CITY OF ALBUQUERQUE  
MUNICIPAL DEVELOPMENT DEPARTMENT  
ENGINEERING DIVISION

HYDROLOGY SECTION PROJ. NO. J-18 DATE: 1/31/84

SUBJECT: Office Building for Ray Tabet

REF: OFFICE BUILDING FOR RAY TABET (J18-D11)

DRAINAGE / GRADING PLAN
OFFICE BUILDING at
Cagua & Haines N.E.

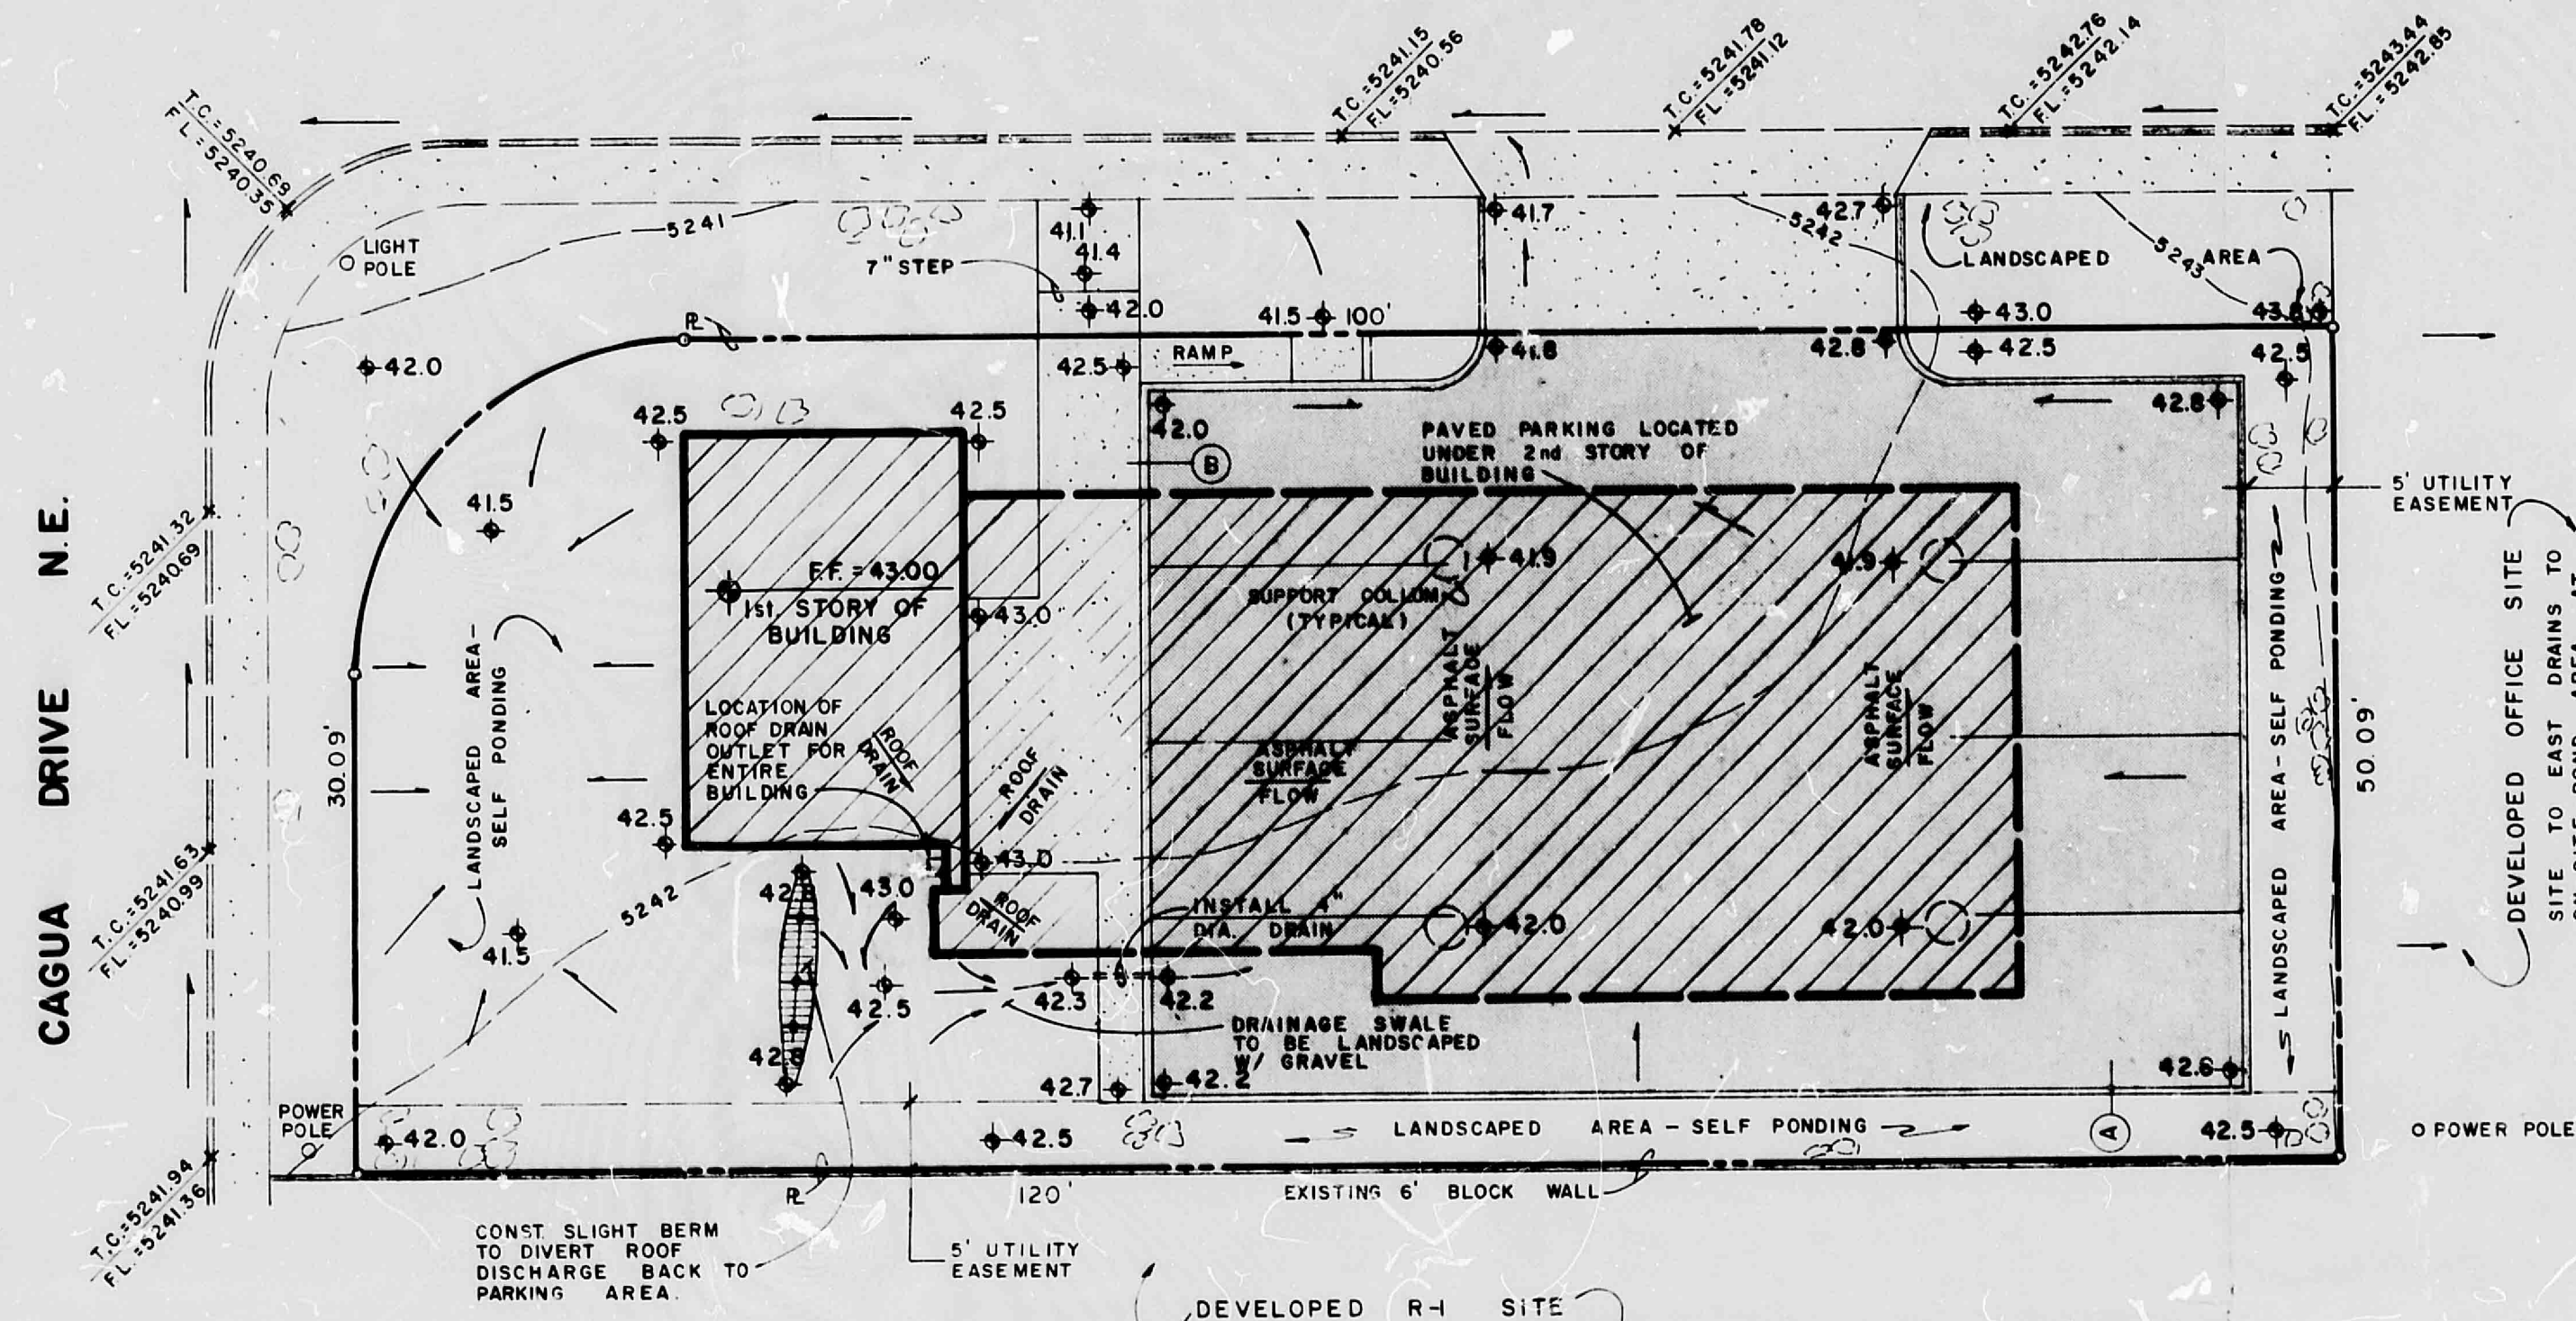
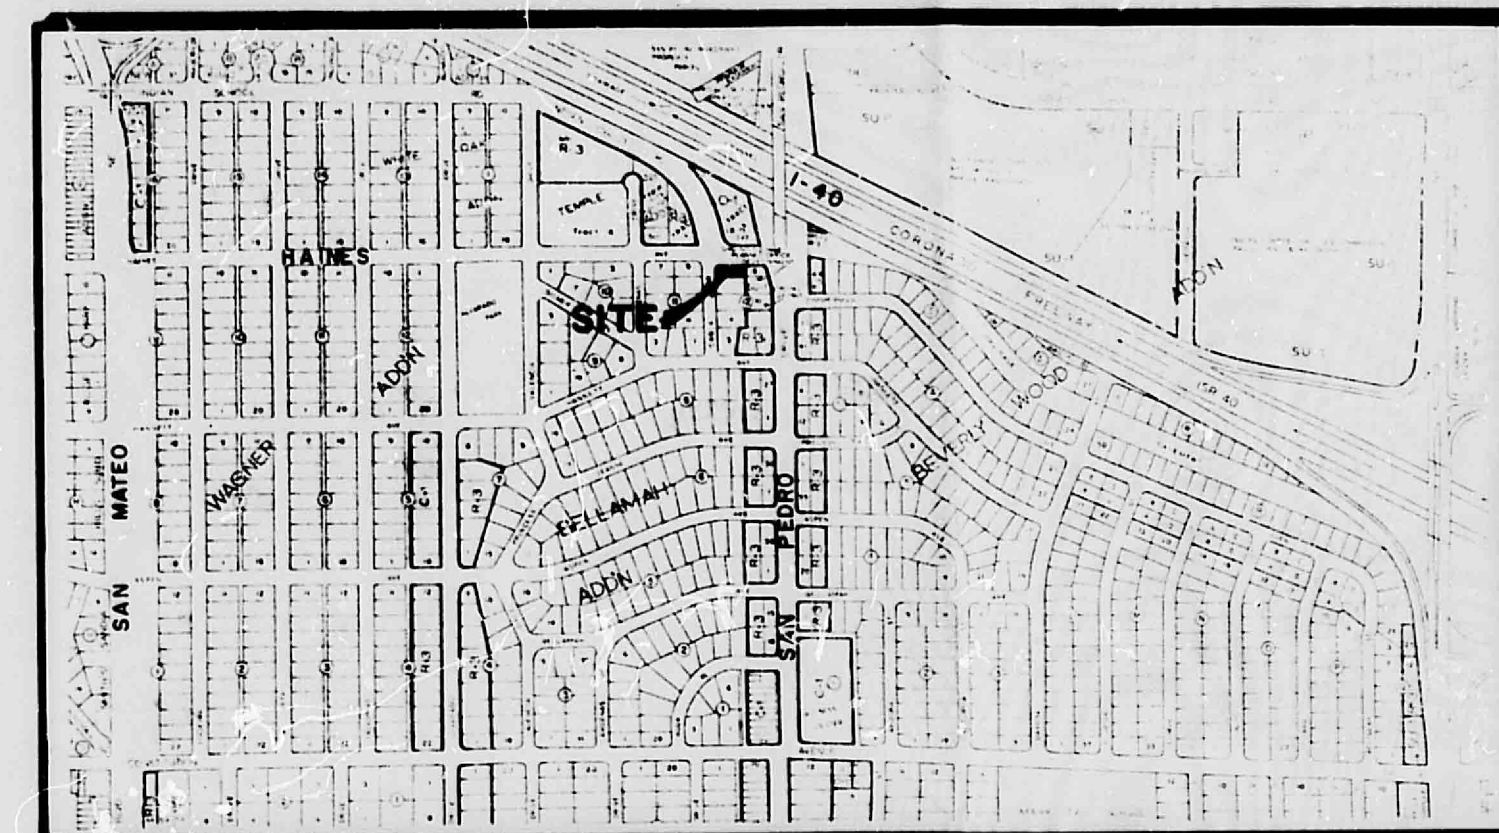
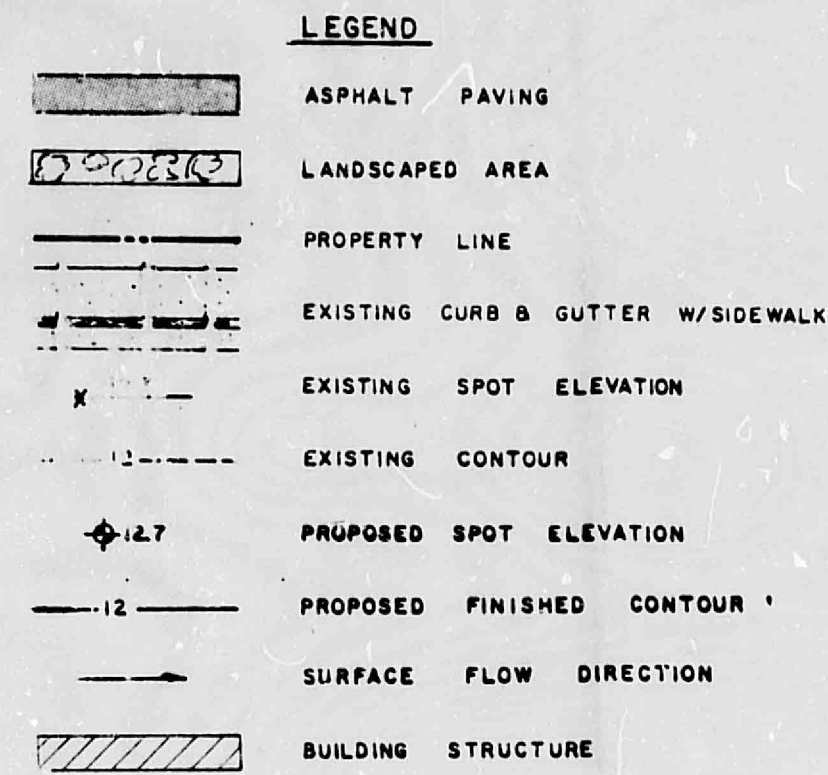
1. Complete information sheet with resubmittal.
2. Professional's stamp with signature and resubmittal date.
3. You will need to address offsite conditions on the east portion of lot. Where is runoff from developed office site directed.

4. On-site conditions that must be addressed
  - a. developed and undeveloped flows (computations)
  - b. amount of flows that will be discharging through the drivepad.

5. What other provisions for erosion control do you propose to route roof runoff towards the 4" pipe. (If possible it may be advisable to route the downspout directly onto the paved area).

6. Benchmarks-location, description and elevation of the
  - a. Albuquerque Control Survey Vertical Datum used.
7. Elevation of property line must be at least .33' above adjacent top of curb. Your plan does not reflect those along Haines Avenue. One alternative may be to justify that the contributing basin entering the area isn't large enough to cause any concerns.
